Vallis & Hall Conservation Arc
Middle Barn
Oak Lane
Chichester
PO20 7FD

Application for Planning Permission for Works or Extension to a Dwelling

Development: Single storey rear/side extension, including the installation of solar panels.
Location: Commonmead Barn Pagham Road Pagham PO21 3PY

I regret that I am unable to accept your documents as a valid application until the following item(s) have been received or resolved :-

Drawing No.
846/PL100

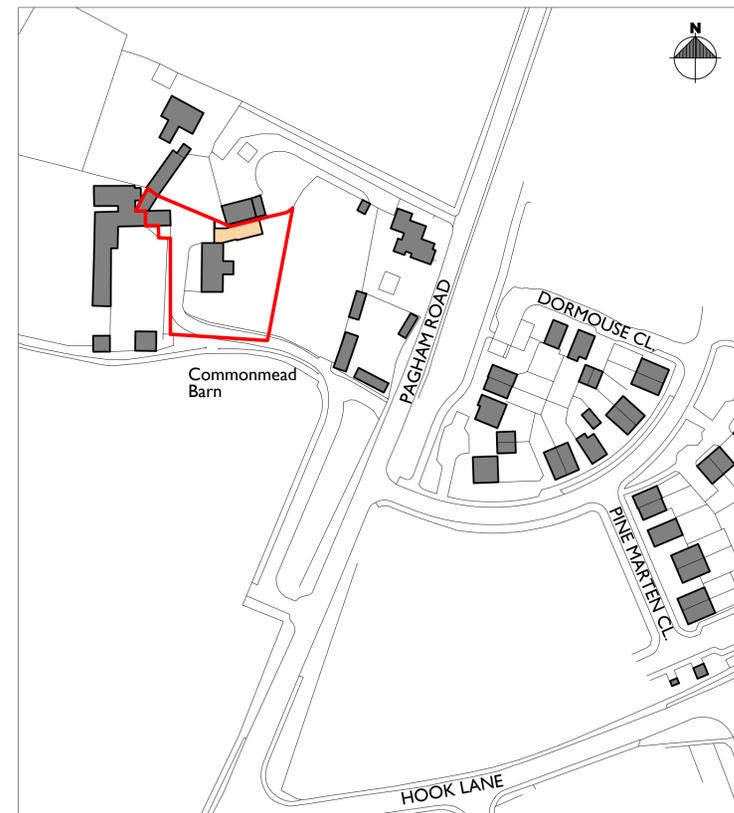
Block Plan

You are required to have dimensions from the proposed extension(s) to all site boundaries. Please amend
